Ribble Valley Borough Council  
Development Control

Application no: 3/2019/1036

Address: Betty Barn, Slaidburn Road, Waddington

Proposal: Conversion of Barn to Residential Dwelling

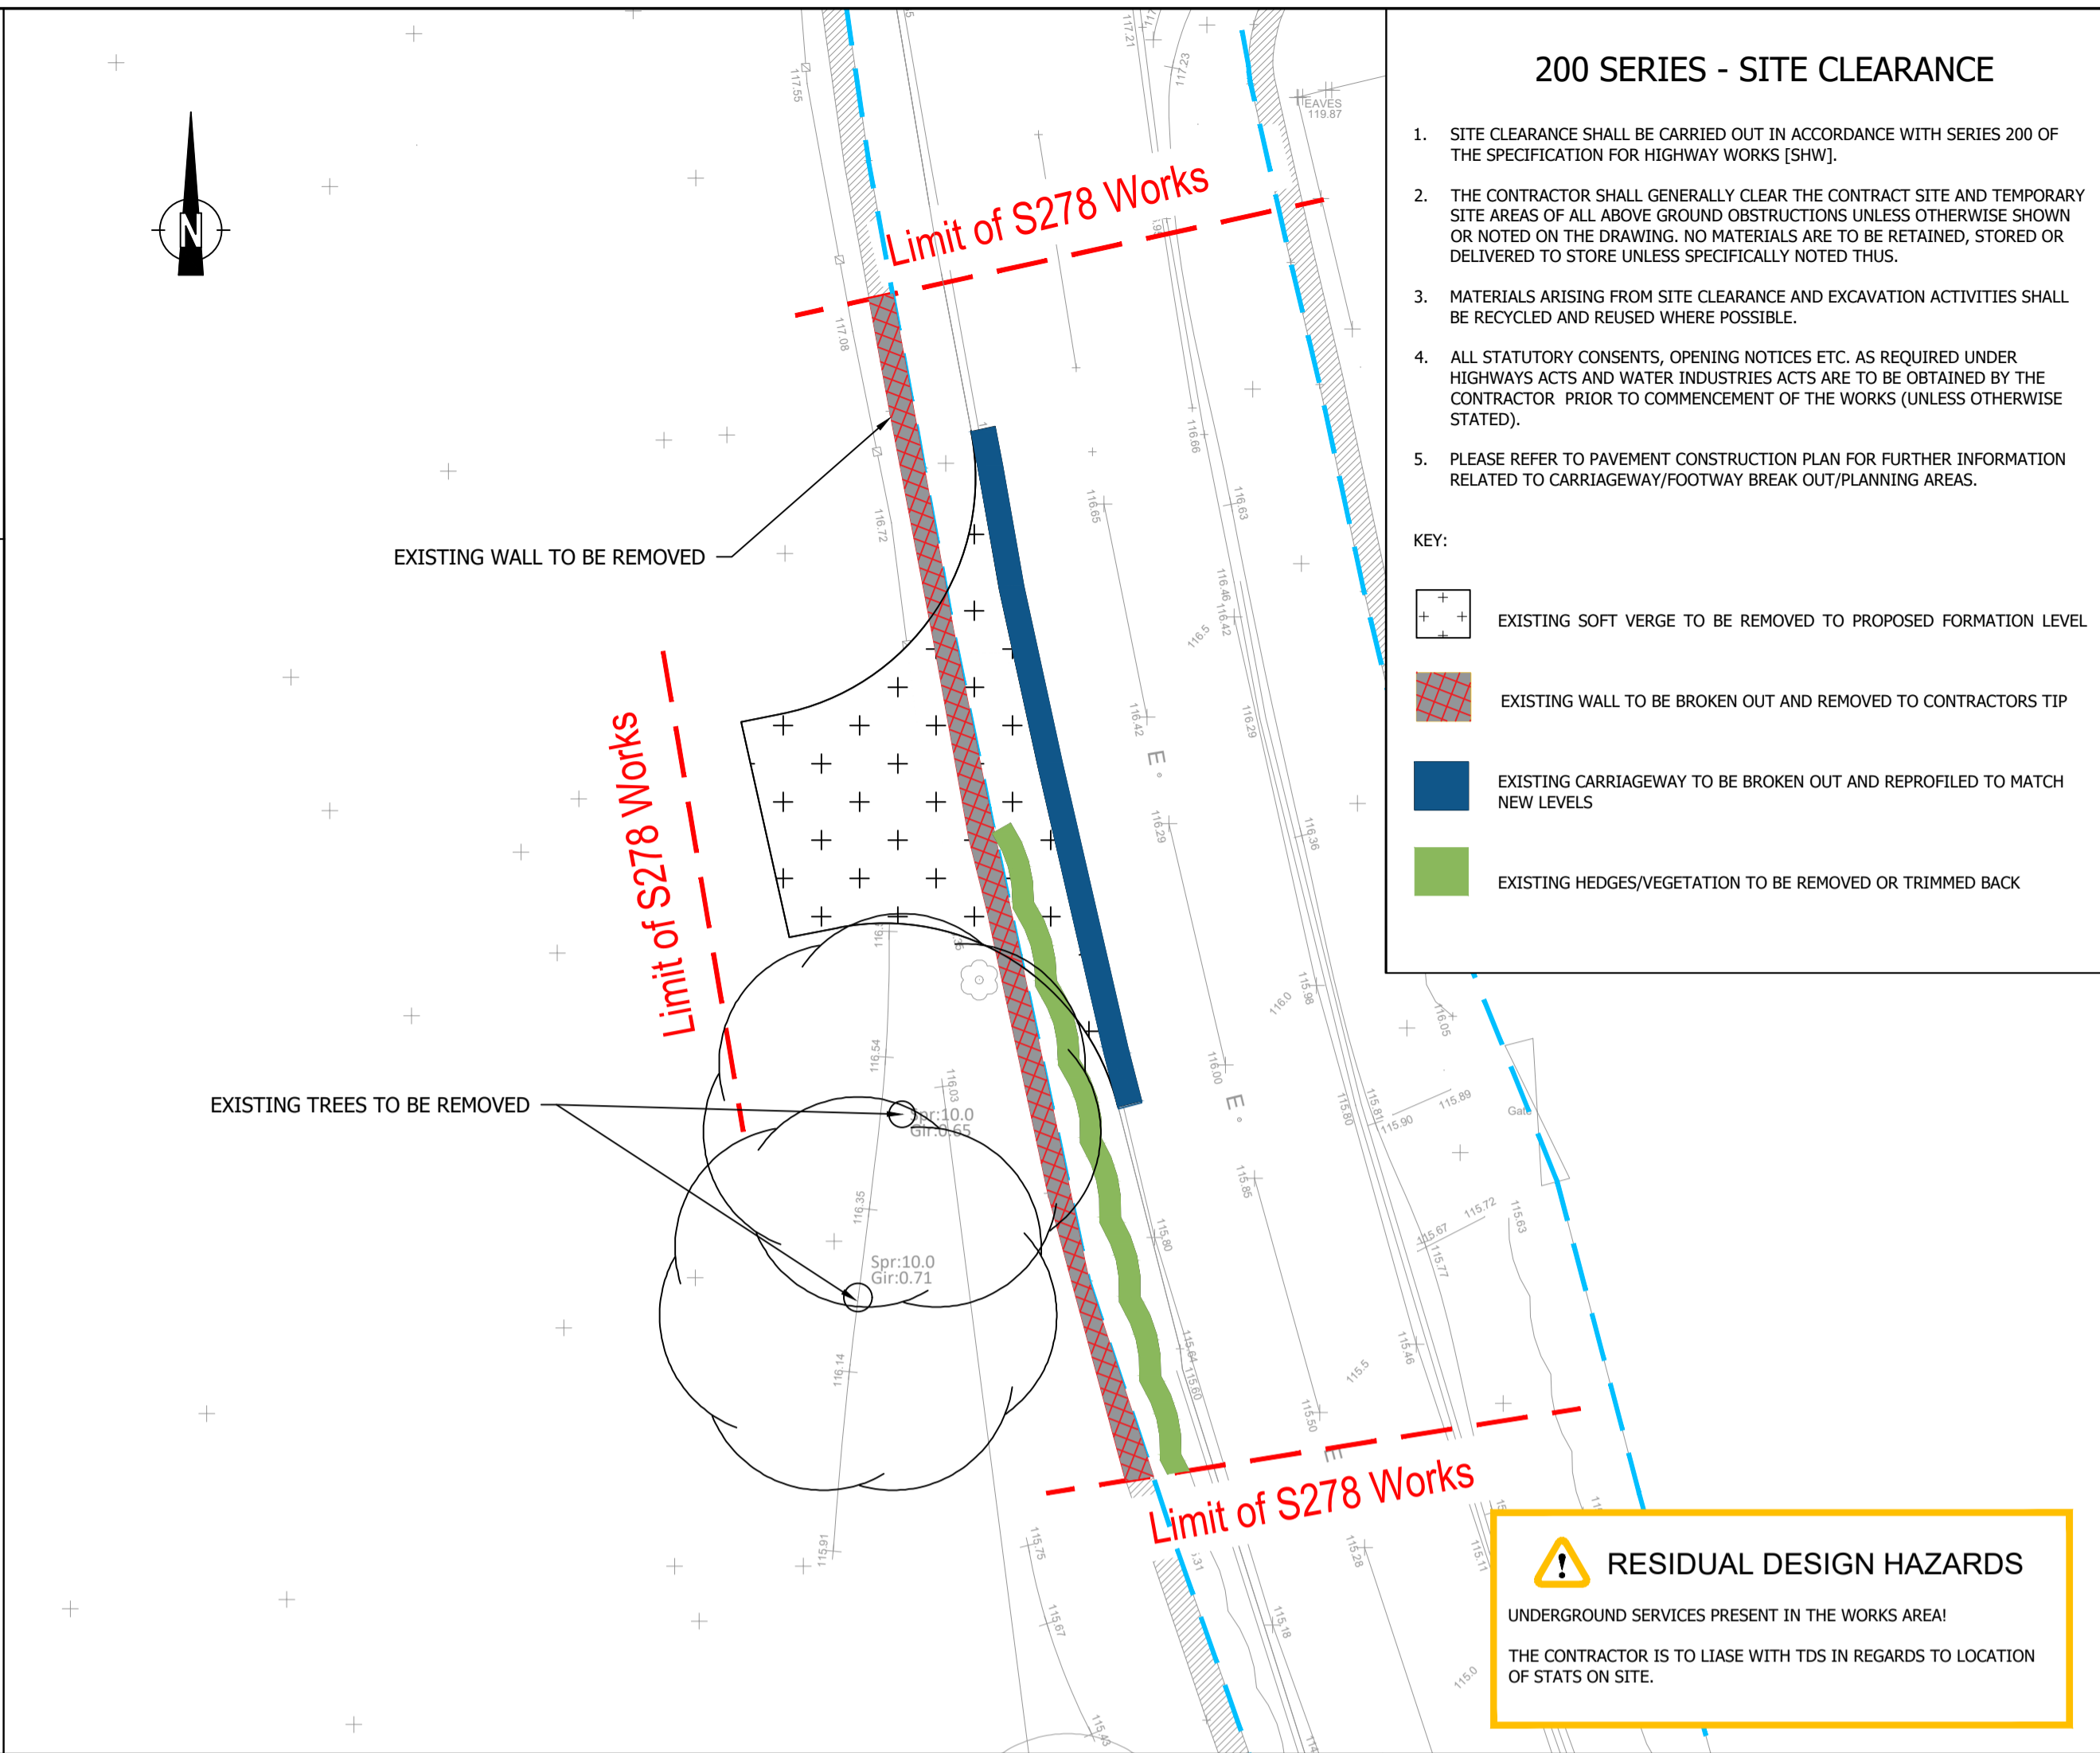
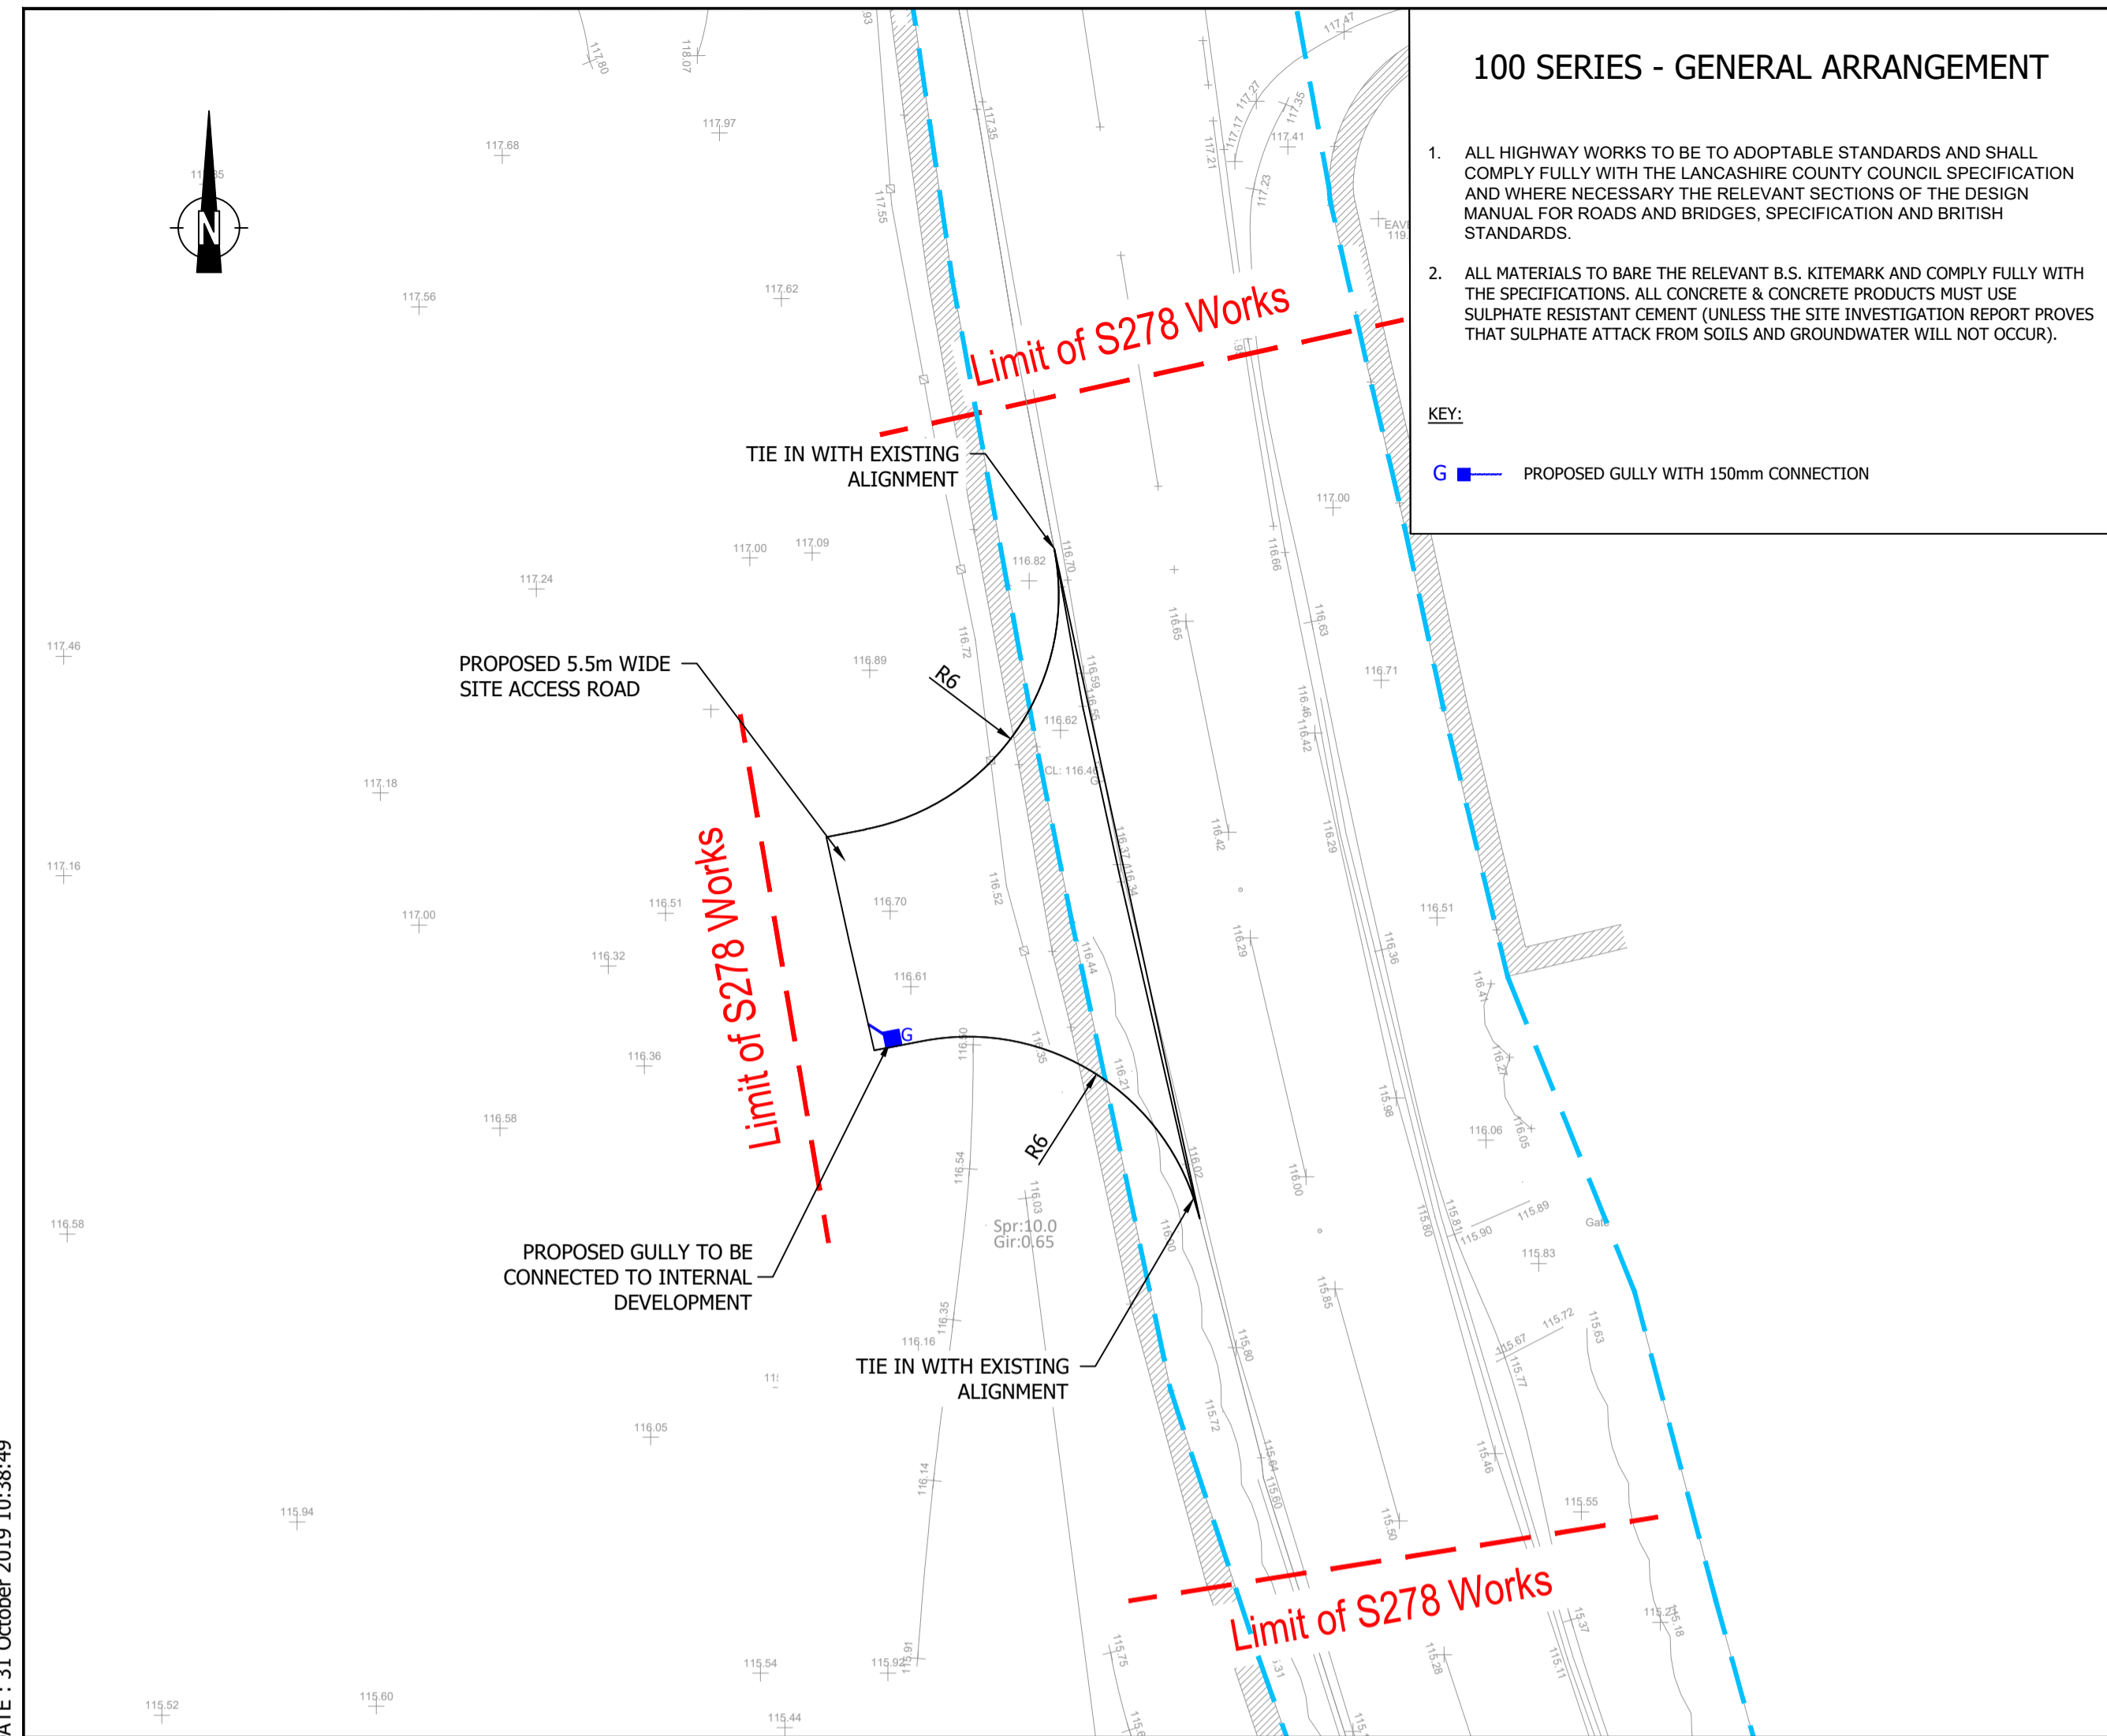
The proposal has been the subject of some discussion between the applicant and the highway authority under the pre-application process. There are inherent benefits in relocation the existing access to the proposed location and this would be considered acceptable to serve the existing users and the additional dwelling. On this basis I would raise no objection to the proposal on highway grounds subject to the following conditions being attached to any planning permission that may be granted

1 Before the access is used for vehicular purposes, that part of the access extending from the highway boundary for a minimum distance of 7m into the site shall be appropriately paved in tarmac, concrete, block pavements, or other approved materials. Reason: To prevent loose surface material from being carried on to the public highway thus causing a potential source of danger to other road users.

2 Notwithstanding the provisions of the Town and Country Planning (General Permitted Development) Order 1995 there shall not at any time in connection with the development hereby permitted be erected or planted or allowed to remain upon the land hereinafter defined any building, wall, fence, hedge, tree, shrub or other device over 1m above road level. The visibility splay to be the subject of this condition shall be that land in front of a line drawn from a point 2.4m measured along the centre line of the proposed road from the continuation of the nearer edge of the carriageway of Slaidburn Road to points measured 70m to the north

and 100m to the south along the nearer edge of the carriageway of Slaidburn Road, from the centre line of the access. Reason: To ensure adequate visibility at the site access onto Slaidburn Road.

- 3 The existing access shall be physically and permanently closed with vehicular access being prevented by the erection of a boundary wall. The existing verge of the vehicular crossing shall be reinstated concurrent with the formation of the new access. Reason: To limit the number of access points to, and to maintain the proper construction of the highway
- 4 The proposed access from the site to Slaidburn Road shall be constructed to a (minimum) width of 5.5m and this width shall be maintained for a minimum distance of 7m measured back from the nearside edge of the carriageway. Reason: To enable vehicles to enter and leave the premises in a safe manner without causing a hazard to other road users.
